East Preston Parish Council
Mr Simon Cross
Council Office
122 Sea Road
East Preston
BN16 1NN

Application No: EP/33/25/PL
Site Address: Seafield Lodge Seafield Road East Preston BN16 1NA
Description of works: Demolition of existing dwelling and construction of 1 No. new dwelling (self/custom build). This application is in CIL Zone 4 and is CIL Liable as a new dwelling.

Thank you for your internet representation made on 2nd May 2025 which has been recorded as an objection with the comments as follows:

Drawing Name  
Elevations -  
Proposed

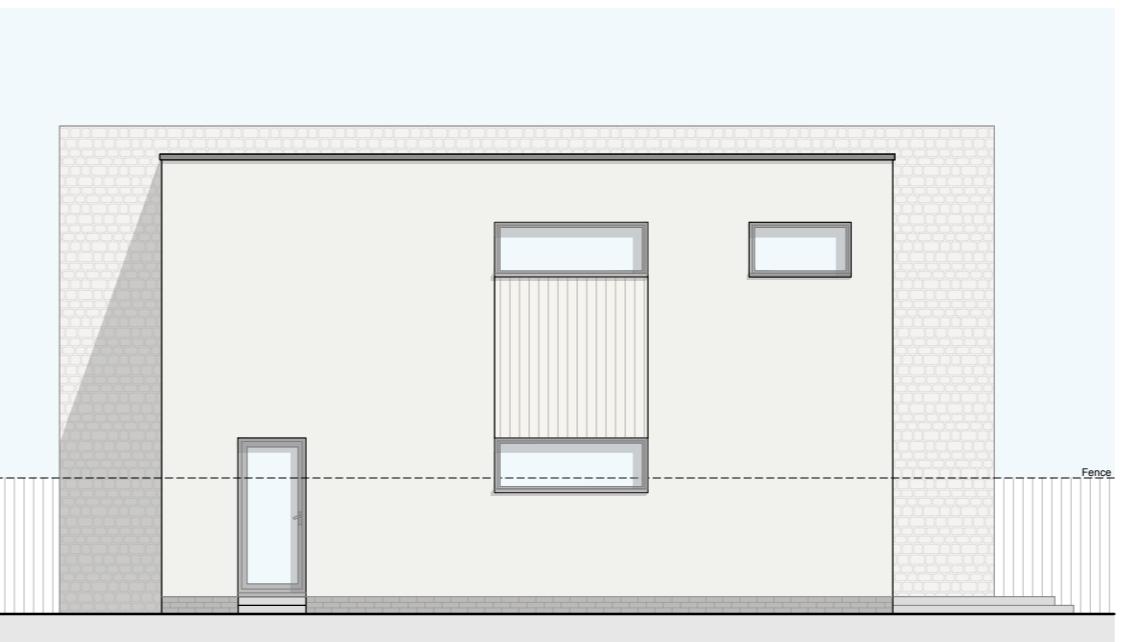
The committee agreed to object to this proposal as it is concerned the proposed design will not be in keeping with the more traditional neighbouring and adjacent properties in Sea Road, Palm Court Cottages and Seafield Road.
